**RE: Sydney Grammar School, Weigall Sports Complex: State Significant Development (SSD-10421):  
Response to Condition B1**

This letter on the Sydney Grammar School Weigall Sports Complex (SSD-10421) is written on behalf of Sydney Grammar School. It responds to SSD-10421 Condition B1 which states:

- B1. Prior to the issue of any construction certificate, the design of Building 1 (Sports Complex building) must be amended and revised architectural plans and documentation demonstrating compliance with the condition must be submitted to, and approved by, the Planning Secretary. The revised design must modify the design of that part of Building 1 located directly opposite 8 Vialoux Avenue (i.e. the building component east of the Building 1 stair core/Multipurpose Hall 4 and including the area above the program pool) to reduce the view loss impact experienced by the north facing living rooms within apartments 1, 5, 8 and 12 at 8 Vialoux Avenue. The amendments to the design must comprise (unless otherwise agreed with the Planning Secretary) the following:

Drawing Title
**WEIGALL SPORTS COMPLEX
BUILDING 01 AND BUILDING 02
APPROVED SSDA / RESPONSE TO B1
CONDITION COMPARISON (SHEET 4)**
Sheet Status
NOT FOR CONSTRUCTION

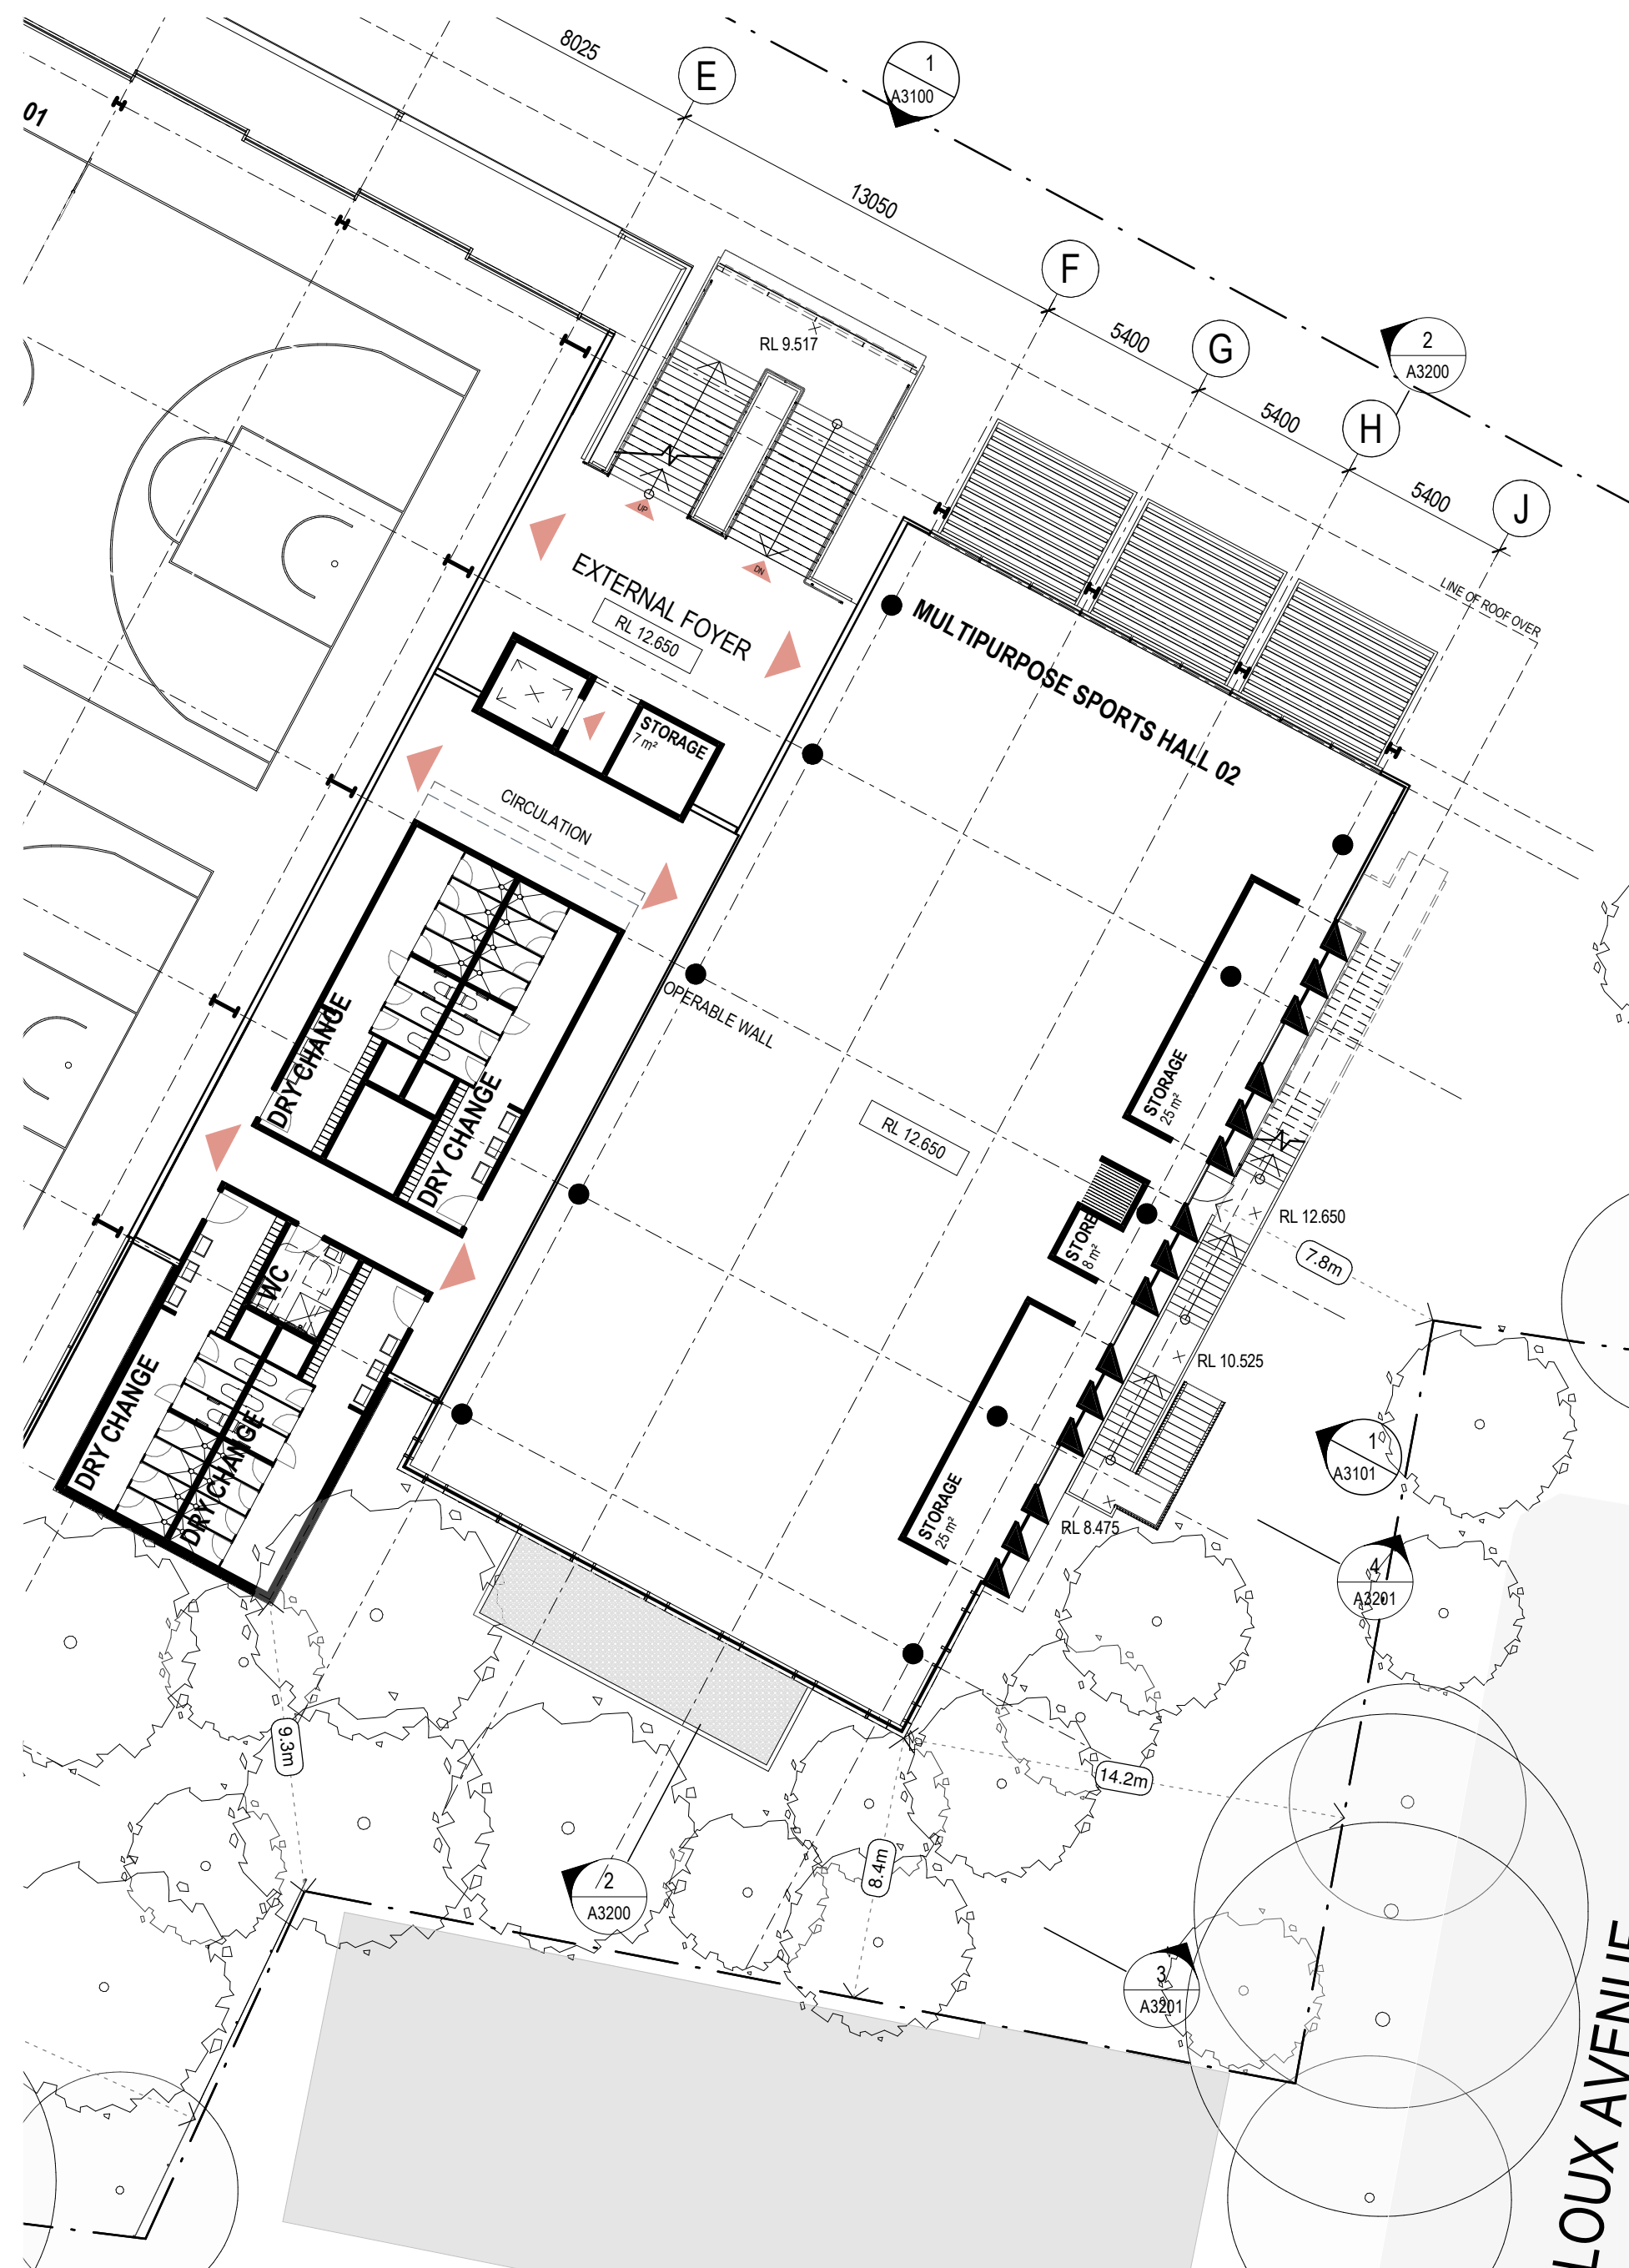
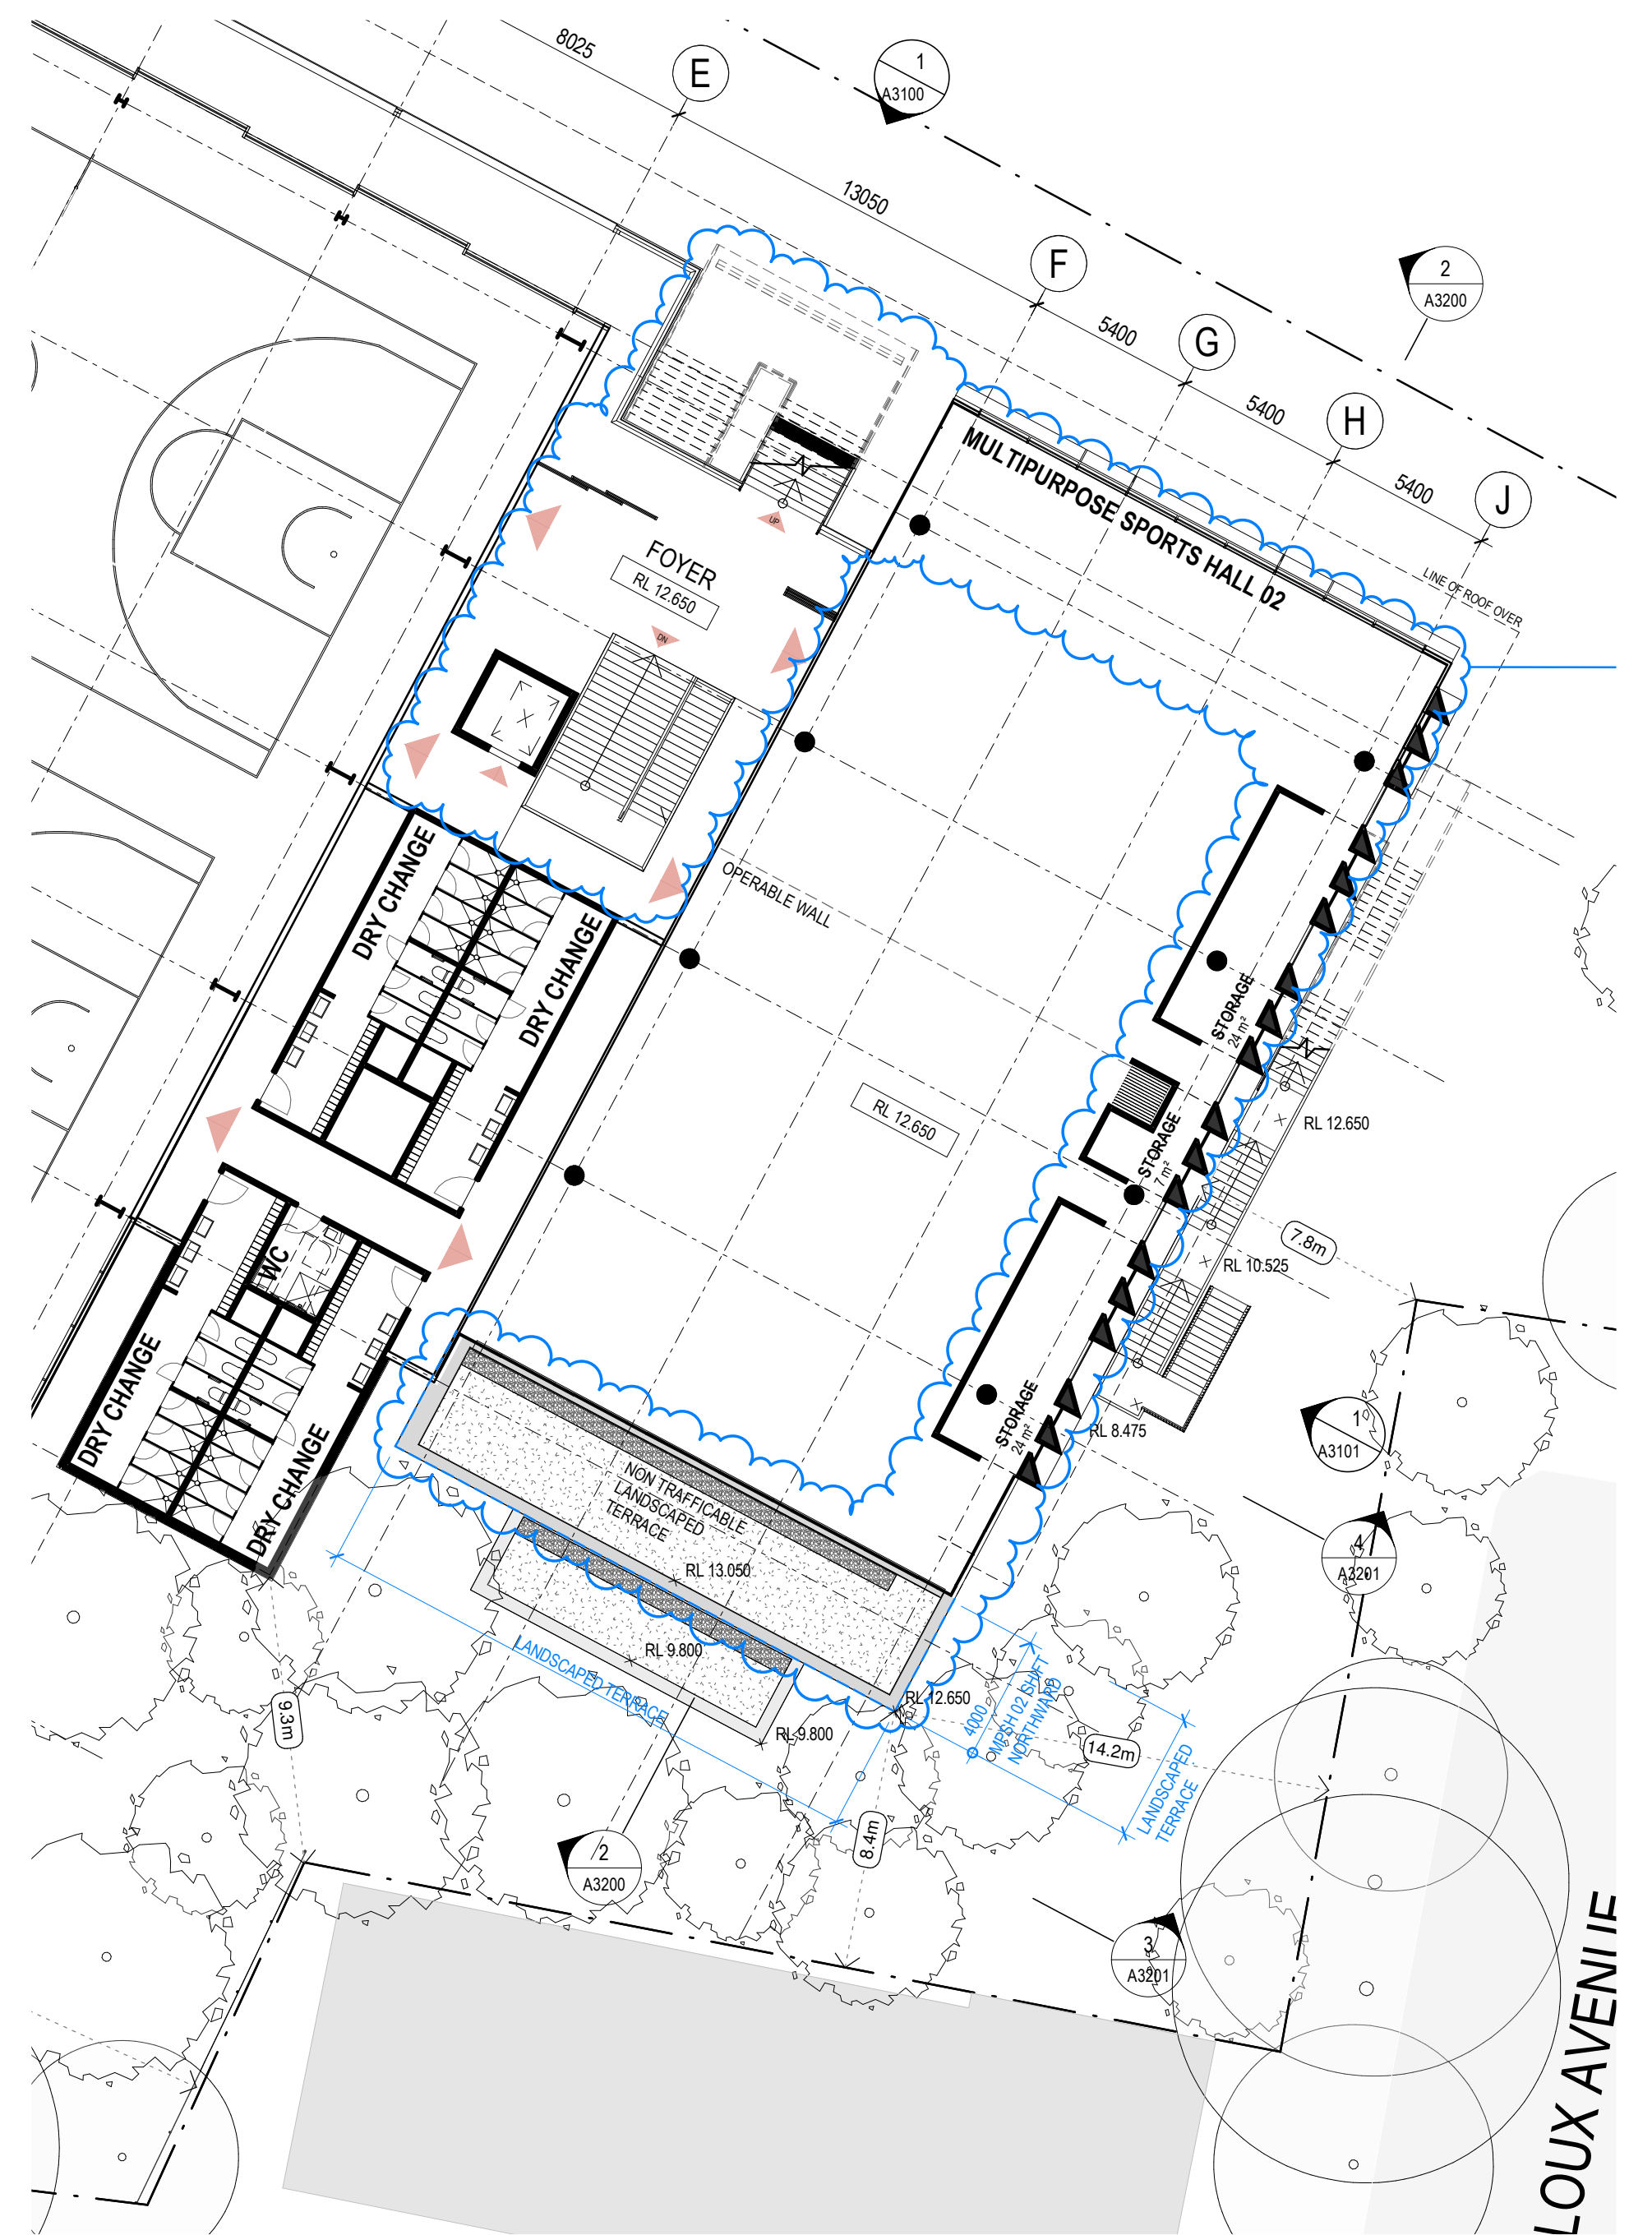
1. Level 1, Multipurpose Sports Hall 2 (see **Figure 1**):
  - Relocated **4m** northward to increase the southern boundary setback
  - Non-trafficable landscaped terrace to the new setback area
2. Level 2, Multipurpose Sports Hall 3 (see **Figure 1**):
  - Relocated **3m** northward to increase the southern boundary setback
  - Non-trafficable landscaped terrace to the new setback area

- (a) relocate the floor plate of the portion of Level 1 accommodating Multi-Purpose Sports Hall 2, further northward by **4m**, to increase the setback of this part of Building 1 to the southern boundary;

- (d) include non-trafficable areas (except for maintenance purposes) and provide roof-top planting along the southern edge of the roofs created from the relocation of the floor plates of Levels 1 and 2 further northward (i.e. the 4m and 3m wide roof areas on Levels 1 and 2 respectively, facing the apartments on 8 Vialoux Avenue).
